PLANNING, HOUSING & ECONOMY

Our ref **10/01780/HYBRID**

Application ref 10/01780/HYBRID, Phase 1 North West Bicester

Title		
EXEMPLAR SITE PROPOSED DEVELOPMENT SURFACE WATER DRAINAGE LAYOUT SHT 1 OF 2		
Drawing No.	Project No.	Issue
7160	UA001881	03

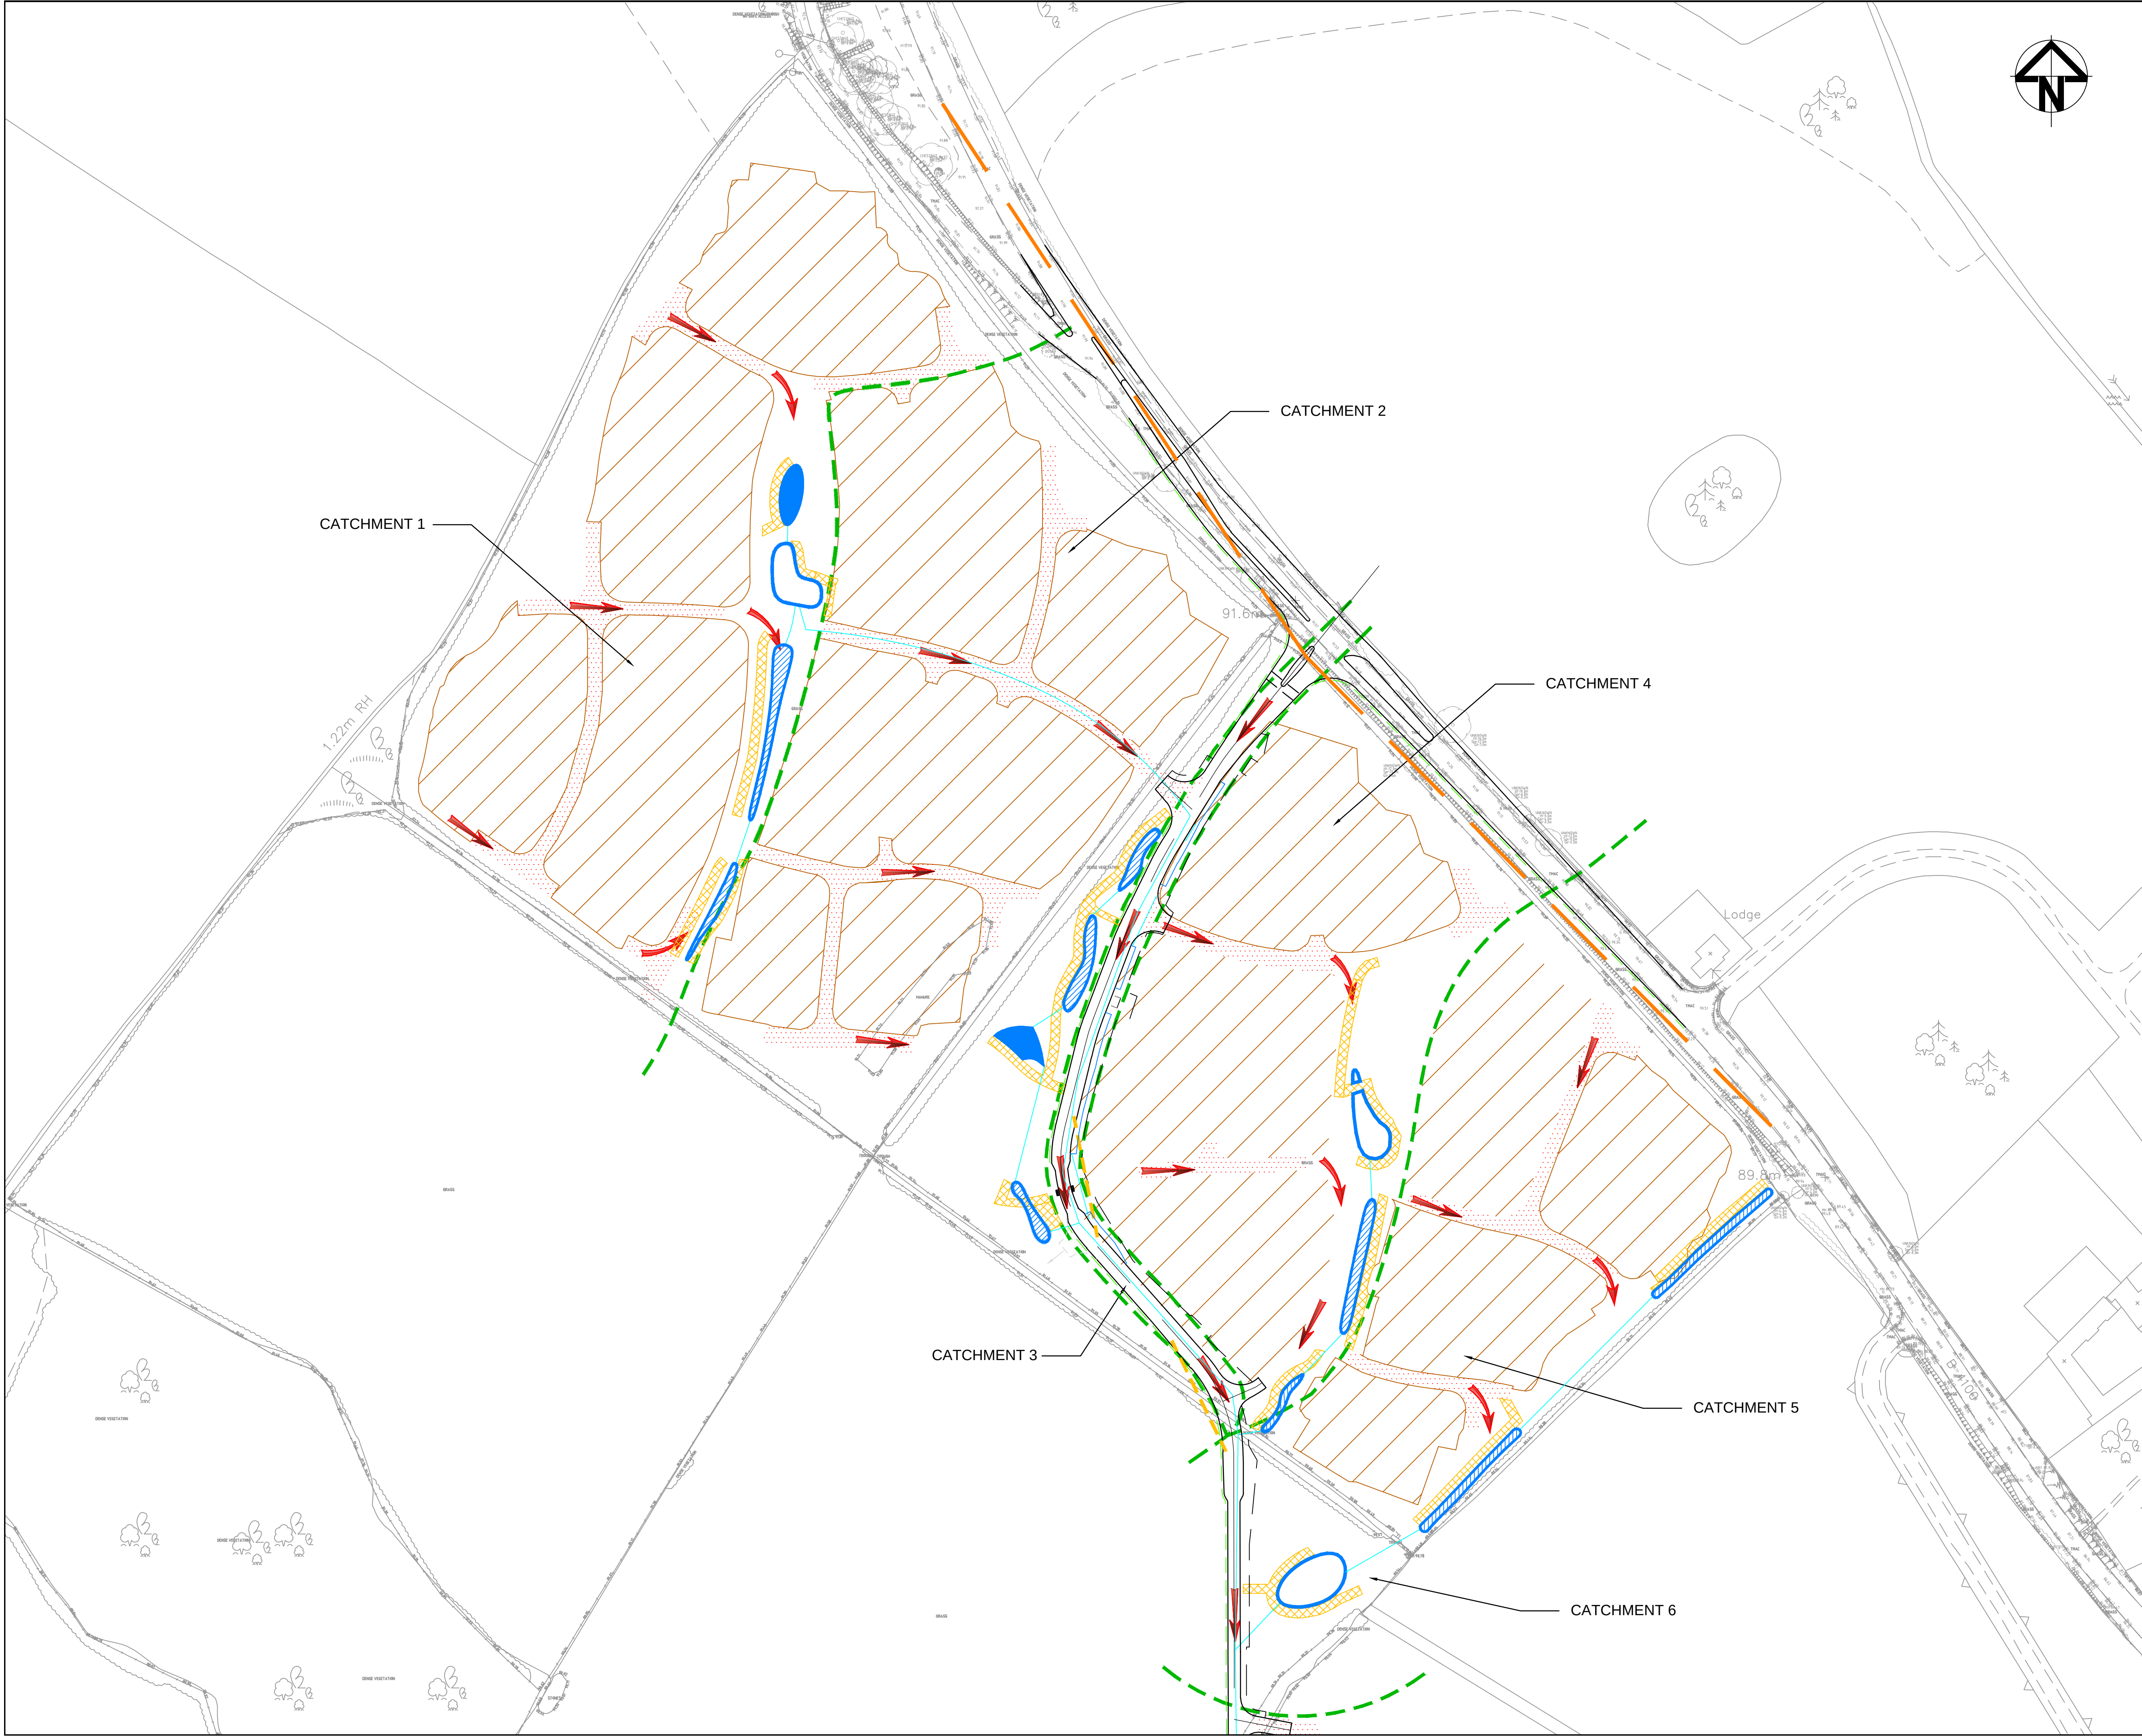
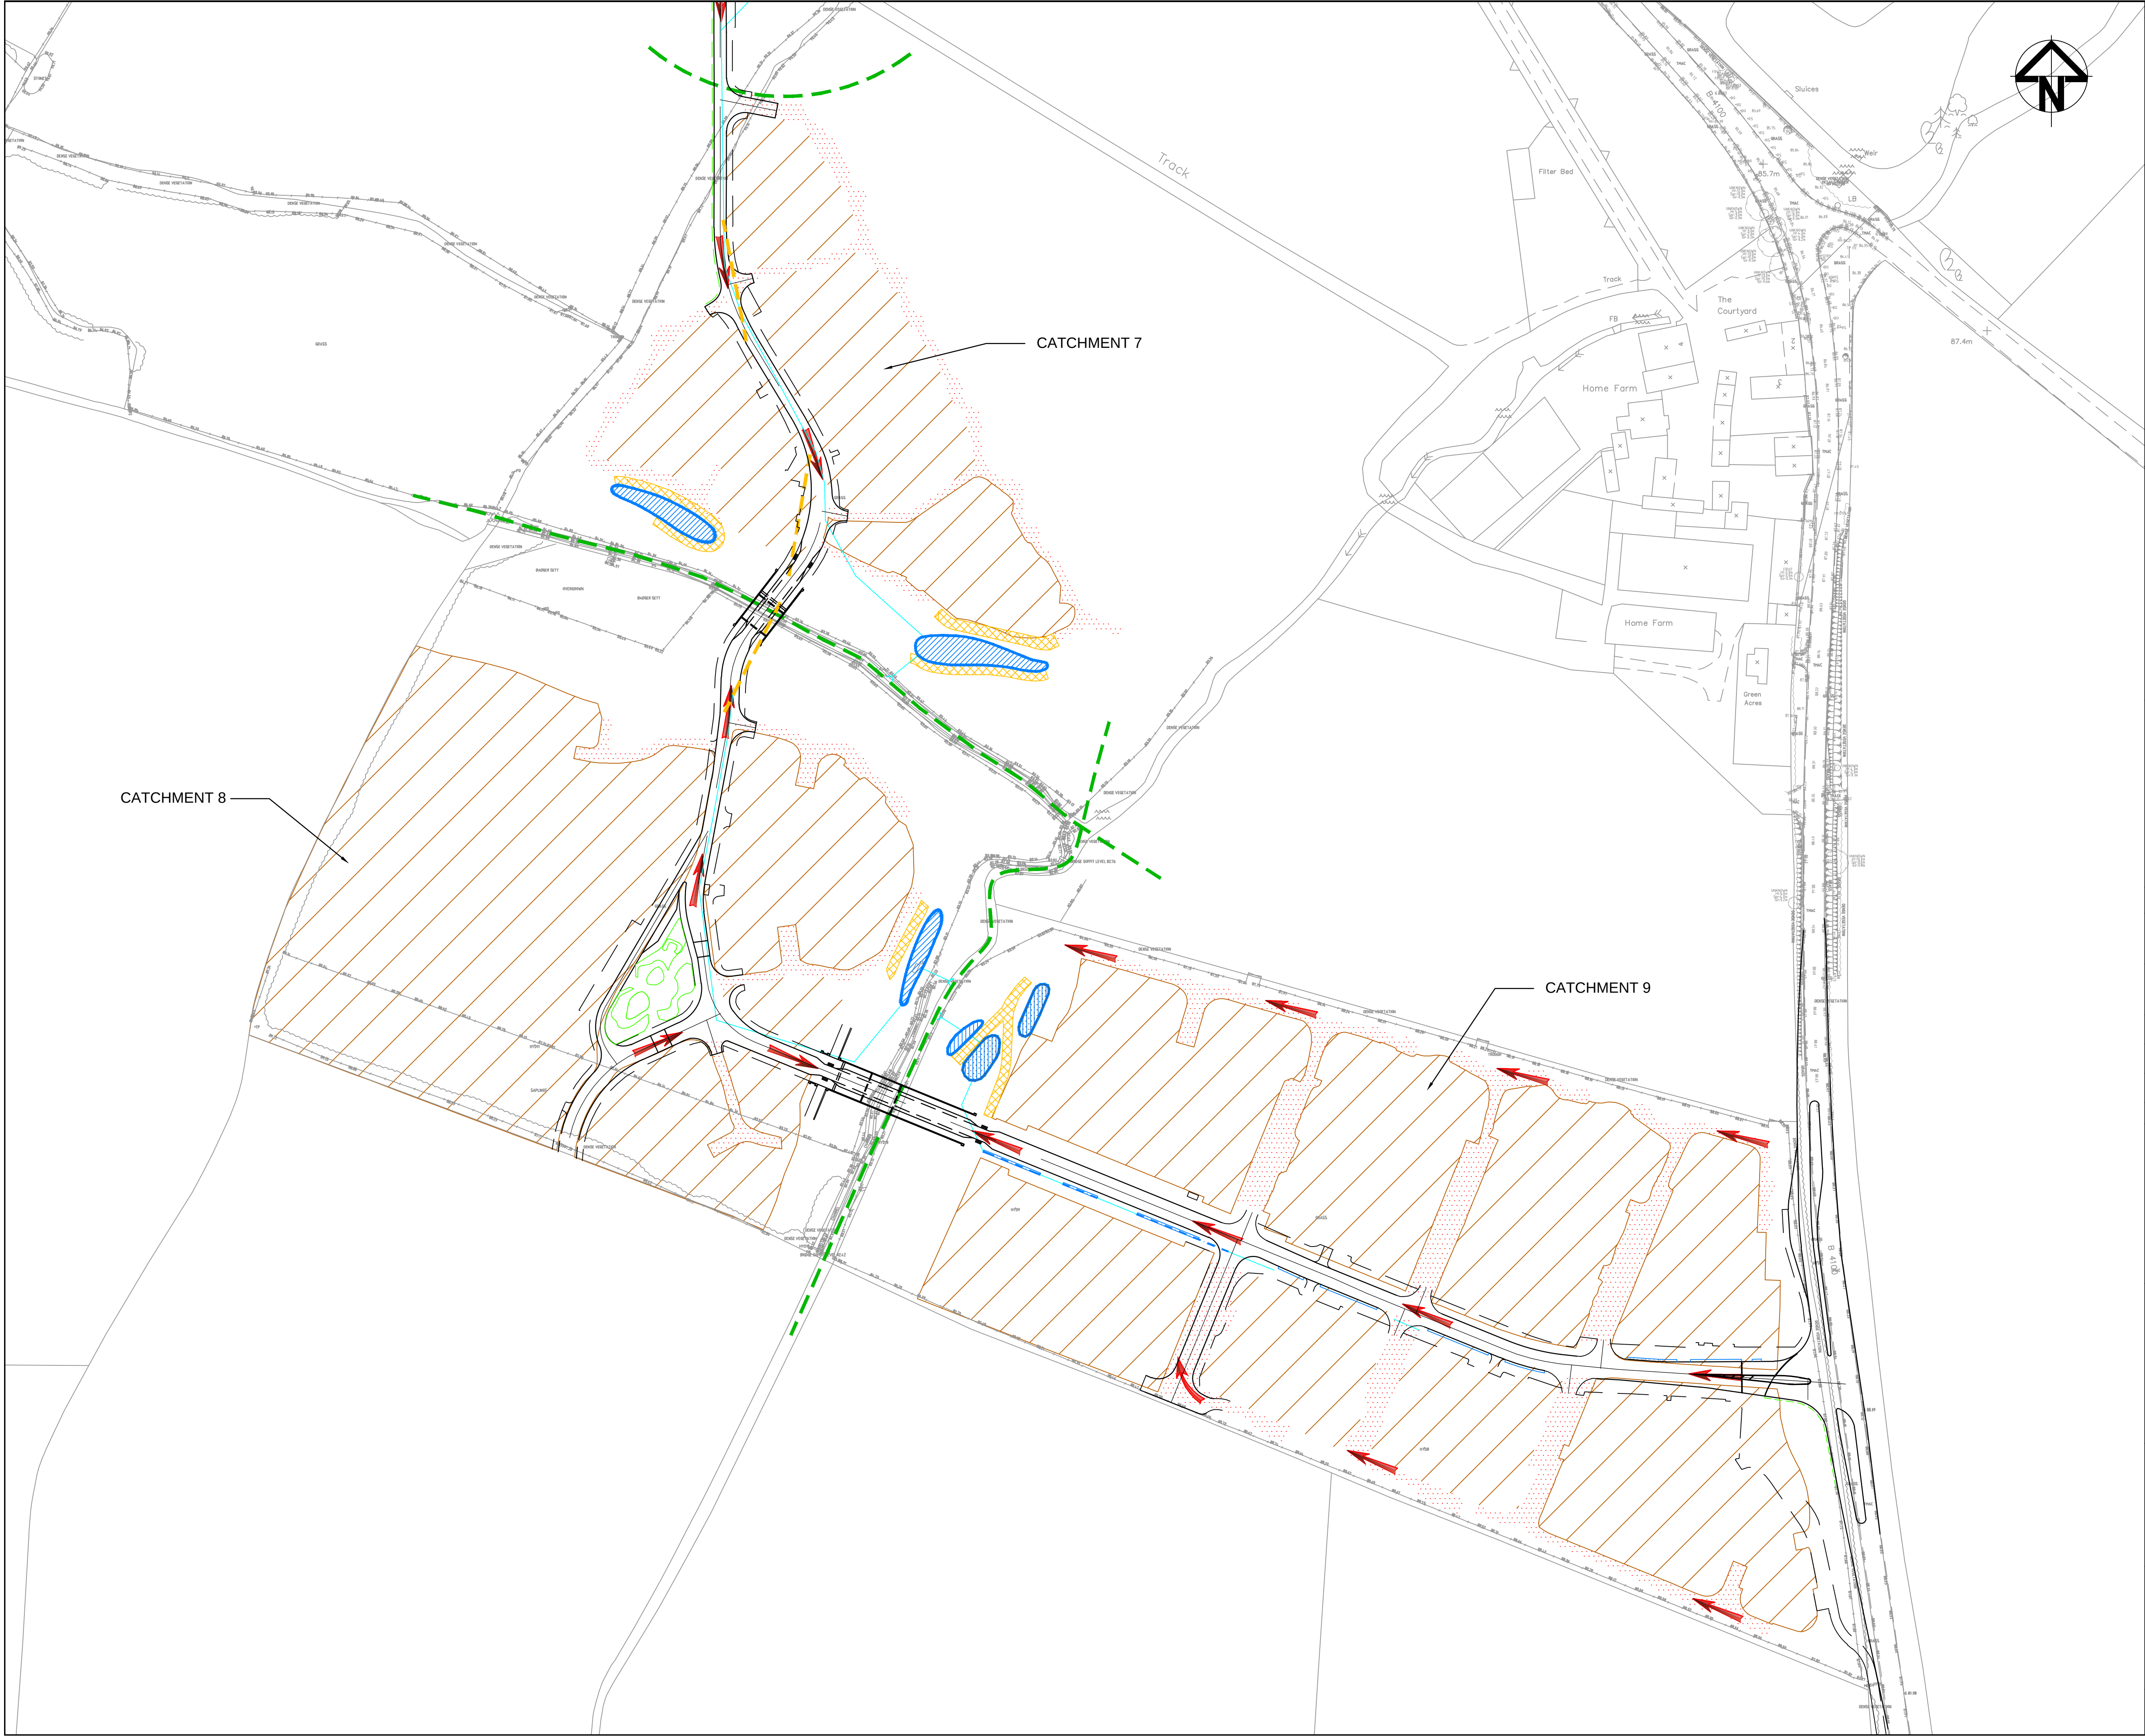
10.2 Of particular concern is the approach to SUDs which relies on underground storage and conveyance structures rather than surface features. This does not represent best practice and is a very disappointing approach particularly given the low density nature of the scheme. The approach to SUDs needs to be reviewed and the proposals improved.
